Lake Lothing
**THIRD
CROSSING**

Document SCC/LLTC/EX/98: Summary of the Applicant's Oral Submissions at Issue Specific Hearing on Navigation Matters of 1 April 2019

Author: Suffolk County Council

Date: 12 April 2019

# North Quay Bollards

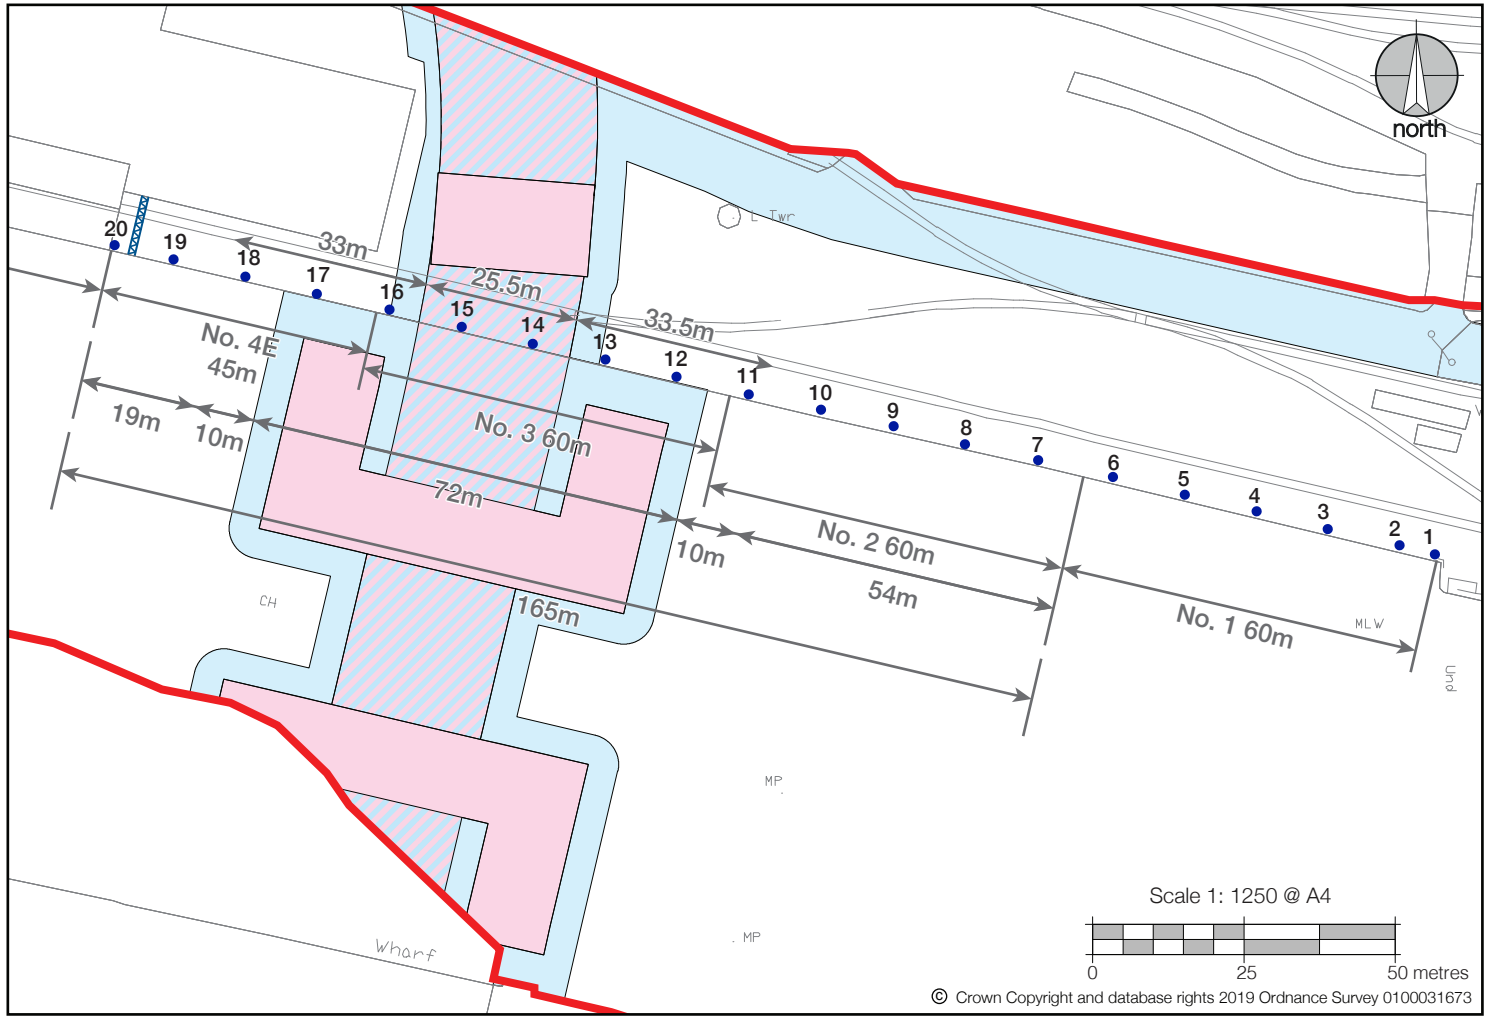
- Thirdly, appended to ABP’s Vessel Mooring Systems in Tidal Ports Paper (REP5-030) is mooring analysis undertaken by ABPmer in relation to North Quay 1 and North Quay 2 berths. Section 4 of that analysis shows bollard positions on these berths and various berthing contingencies. It is clear from that large vessels (such as Britannia Beaver (99.95m LOA)) can continue to berth across North Quay 1 and North Quay 2, with the Scheme in place. The Applicant would also note that the bollard arrangement in this report is incorrect and the overall effect is to omit a bollard.

3.1.7 The Applicant has therefore produced a further figure (appended) which shows the position of the Scheme and its land take in relation to the bollard positioning along north quay. The bollard positions are verified from onsite topographic survey. The effect of the Scheme is to remove access to up to four bollards. The distance between the bollards east and west of the Scheme that may continue to be used is 60.95m, therefore confirming that the 62m of quay that the Applicant has identified as being lost to the Scheme is an accurate reflection of the impact of the Scheme. Further inspection of this drawing indicates that, for certain vessels, the outermost two of the four lost bollards may remain useable for head or stern lines as, dependent on the locations of fairleads on the vessel, there would be no physical impediment to lines laid to these bollards. The Applicant does not consider, given the positioning of the bollards that remain available, that there is any need for, or benefit in, repositioning bollards but is willing to discuss this matter with ABP, as noted above.

3.1.6 ABP have indicated that there are various physical constraints to how they are able to operate at the berths adjacent to the Scheme, for example the locations of bollards and fences. However, ABP have acknowledged that these are a legacy of past operations at the Port and it is the Applicant’s opinion that, should it improve capabilities to operate in these areas post Scheme construction, alterations to these features could be undertaken, and the Applicant is willing to discuss the necessity and delivery of such works with ABP.

Figure 2. North Quay Berths and location of the proposed LLTC Bridge

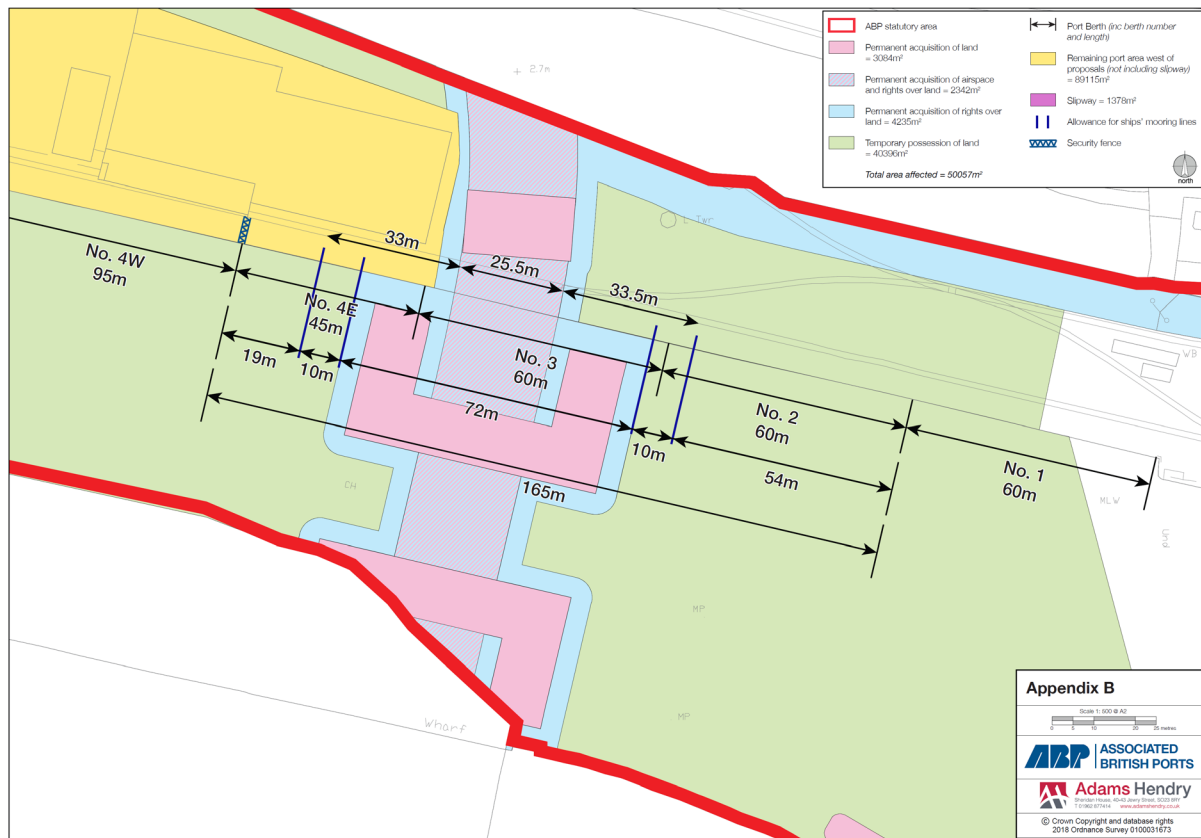
3.1.2 The BUR sets out in section 1.1 a number of overarching statements, that as a consequence of the Scheme:

- North Quay 2: “effectively lost due to its limited utility”
- North Quay 3: “lost in entirety” and
- North Quay 4 East: “effectively lost in entirety”

3.1.3 ABPmer goes on to state that ABP considers it would not be practical or feasible to rearrange bollard restraint points and thus longer vessels that would normally span a number of these berths would be displaced, and consequently considers the berth loss is 165m. This position is also conveyed in chapter 10 of ABP’s Written Representation.

3.1.4 ABP has claimed that berth loss should be calculated in relation to whole berths, as identified by their historic berth numbering, and that any berth that is potentially affected, regardless of how small the effect may be, should be considered as if it were lost in its entirety for all potential operations.

3.1.5 The Applicant considers this to be a gross exaggeration of the impact should the Scheme be built, a position that is to some extent backed up by evidence submitted by ABP themselves:

- 3.1.11** In summary, the total length of quay that will be unavailable for vessels to berth against on completion of the scheme is 62m (including up to four bollards) and this is the only length of berth that should be considered as a direct loss.

- 3.1.12** While other lengths of quay may have a reduction in functionality under current operational circumstances, this is not to say that they will continue to suffer such in the future as operational requirements will change (for example in relation to the creation of a dedicated aggregates berth, as envisaged by ABP). These impacts could be further mitigated with minor accommodation works, such as repositioning of fencing and provision of fenders.
